**NEWCASTLE JOCKEY CLUB NEW STABLES COMPLEX (SSD-12982045) 125 CHATHAM STREET BROADMEADOW**

I refer to the Department's electronic notification of 13 October 2021 advising a State Significant Development Application (SSD-12982045) has been submitted for the construction of new horse stables and training facilities and requesting City of Newcastle (CN) to provide advice.

The exhibited Environmental Impact Statement ('EIS') and plans have been reviewed and the following advice is provided for your consideration:

SITE PLAN
Scale 1:1000 @ A1

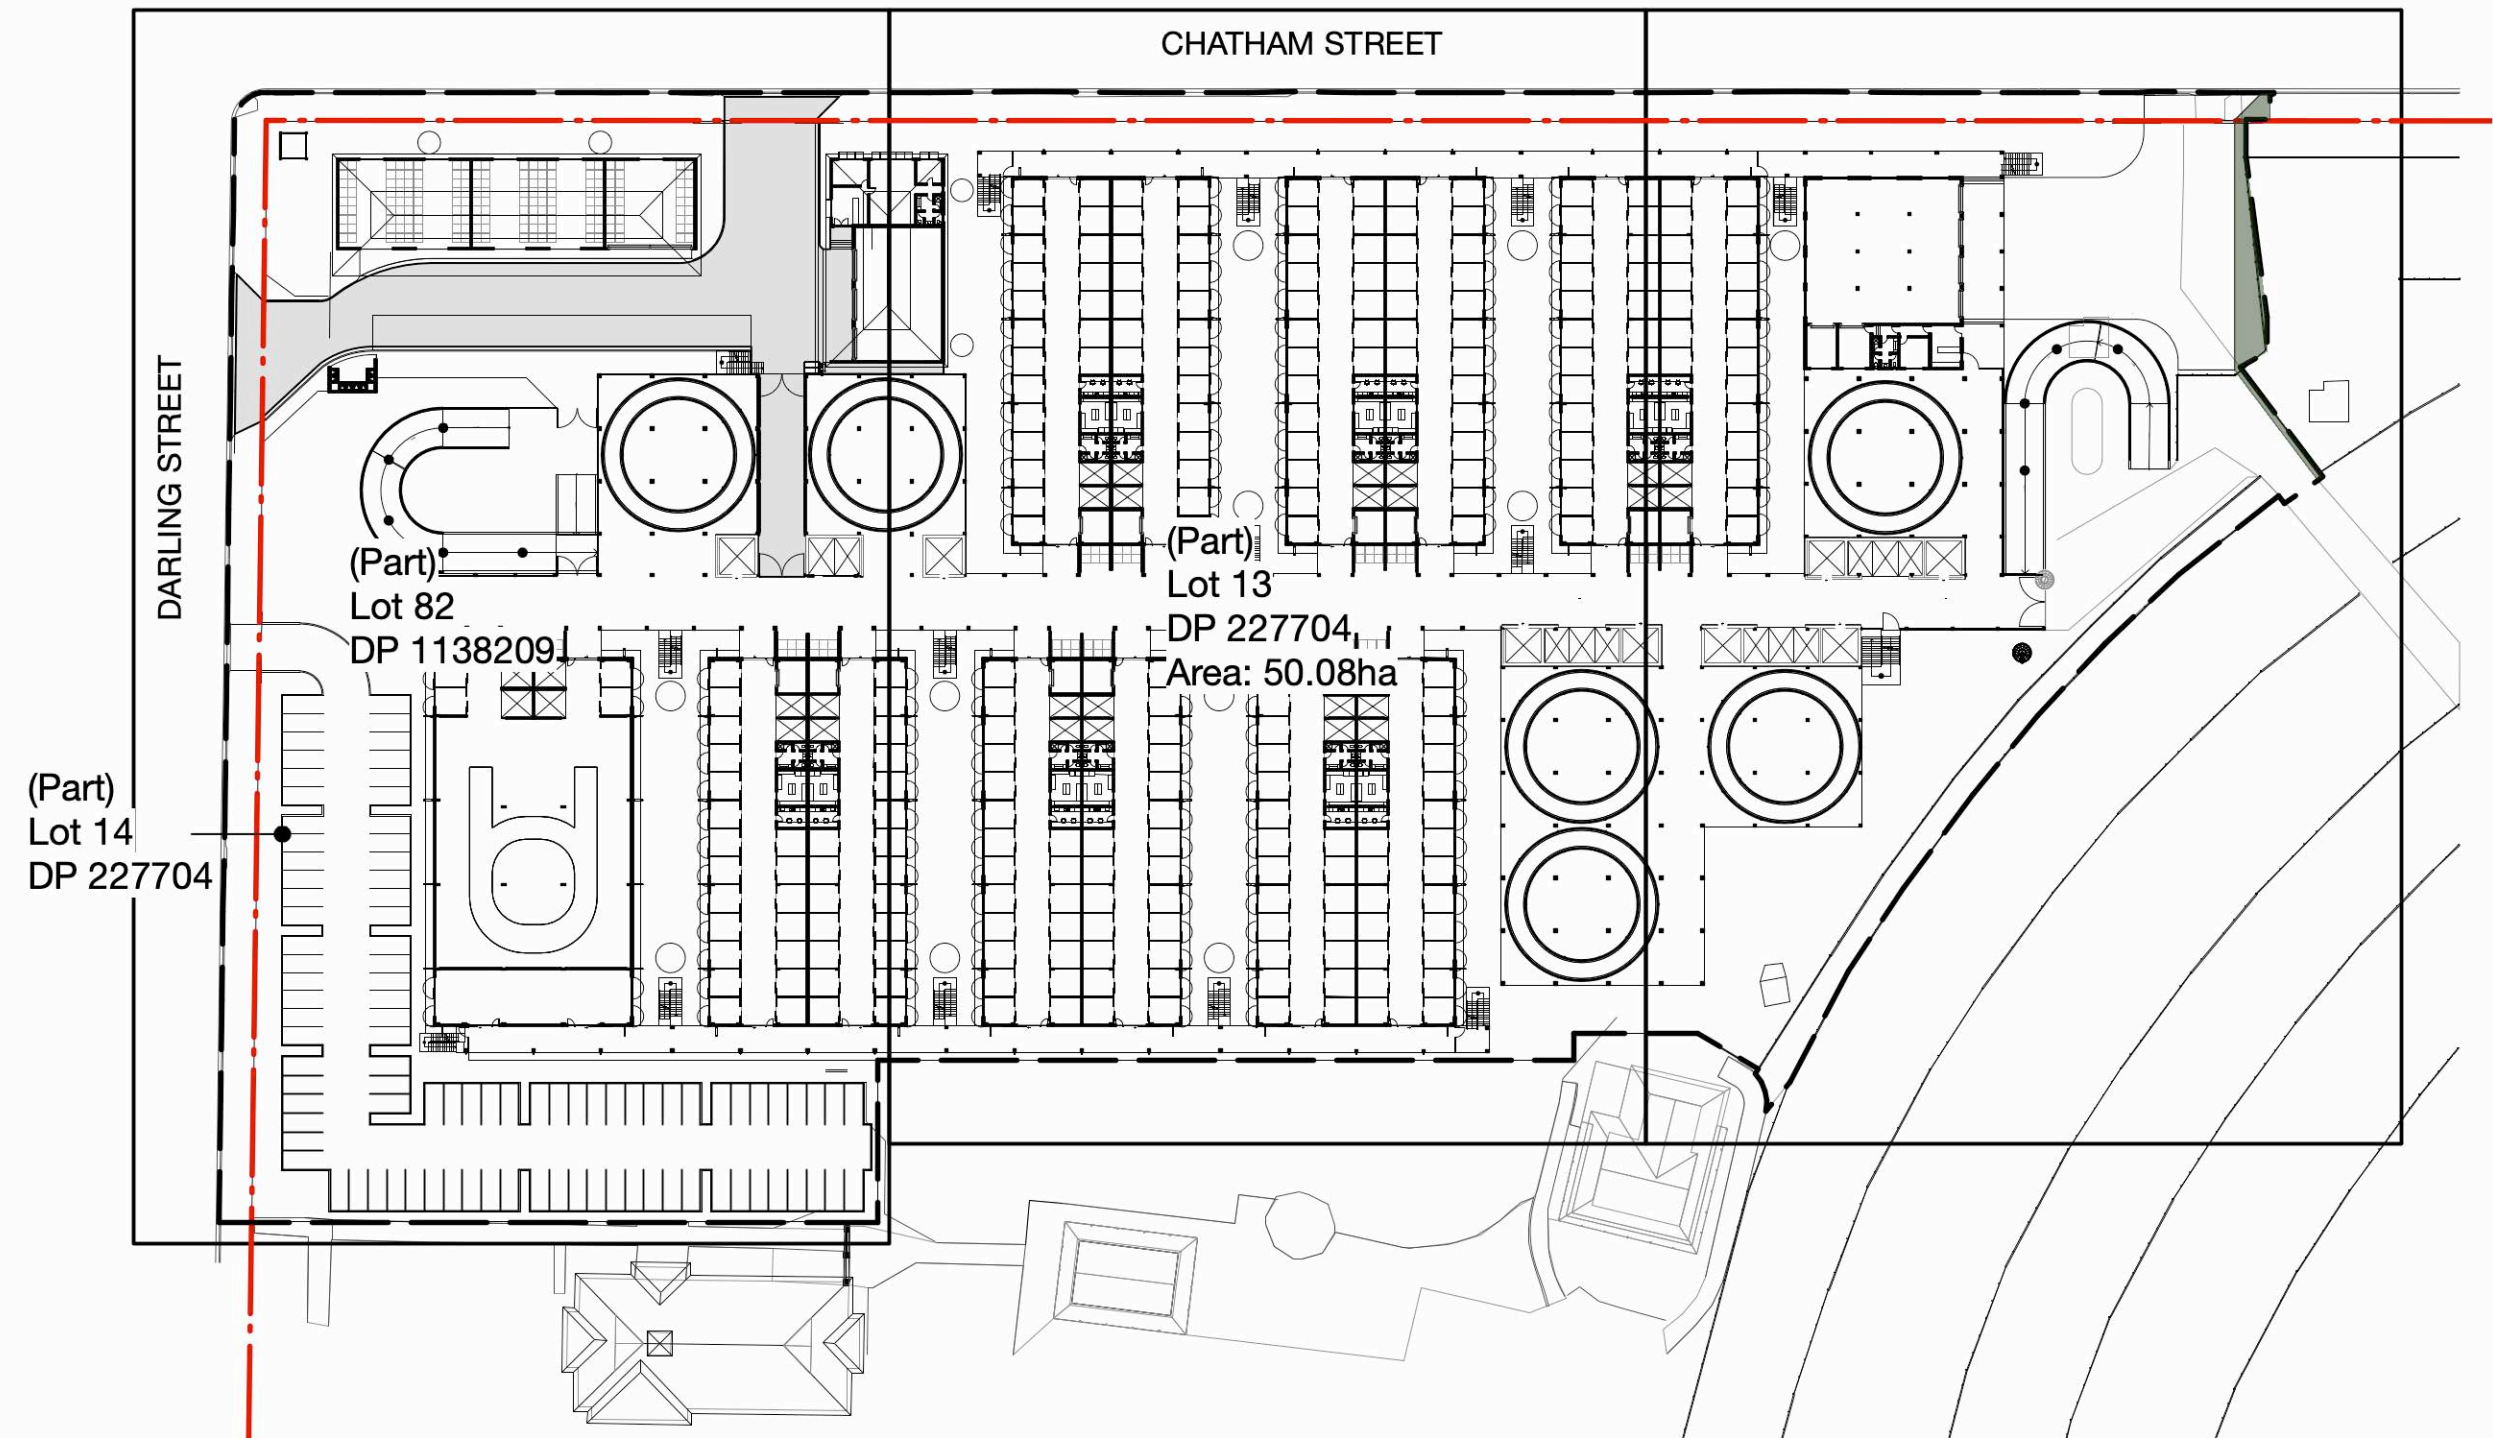
It is noted that landscaping works indicated on the architectural plans and aerial views are not consistent with that shown on the landscape plan. For example: the architectural plans show significant tree planting on site, while the landscape plan refers to tree plantings in the public domain. Furthermore, the scale and bulk of the proposed development is not shown relative to the existing residential and educational development in the locality of the site. The plans also do not indicate the proposed 2.4m high acoustic fence along the western site boundary opposite the proposed Maintenance Shed. It is recommended that the applicant is required to submit amended architectural plans and aerial views which address the above concerns.

Figure 8: Proposed Access points to the stable development (Source: EJE Architects)

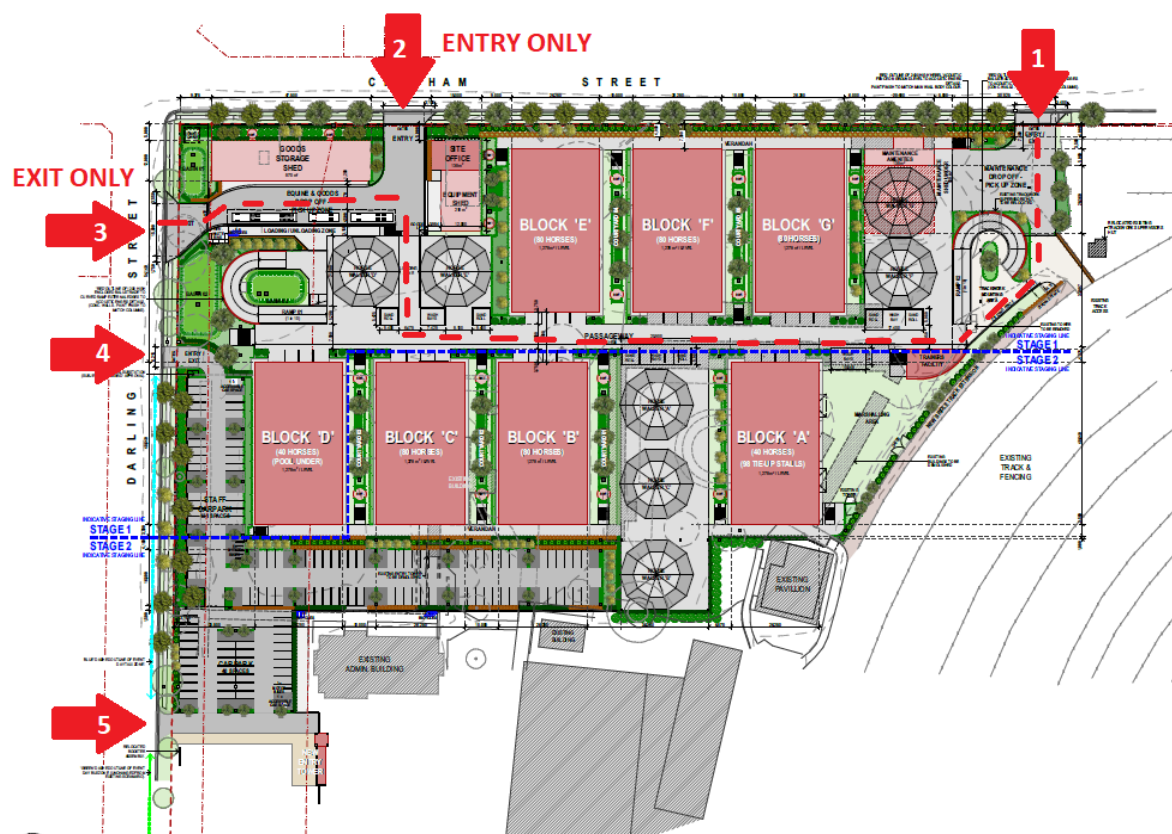
- The intersection of Chatham Street and Darling Street is already congested during race days and a roundabout as an immediate road infrastructure device is required to manage both traffic on race days and that generated by the proposed development. Traffic signals may be required as a long-term solution. The provision of these devices will impact on the design of the development, in particular the proposed Signage Tower, Basin 1 and Goods Storage Shed. At a minimum, a splay will be required on the south-west corner of the development site similar in dimensions to that on the northwest corner of the intersection. It is recommended the applicant submit amended design plans.
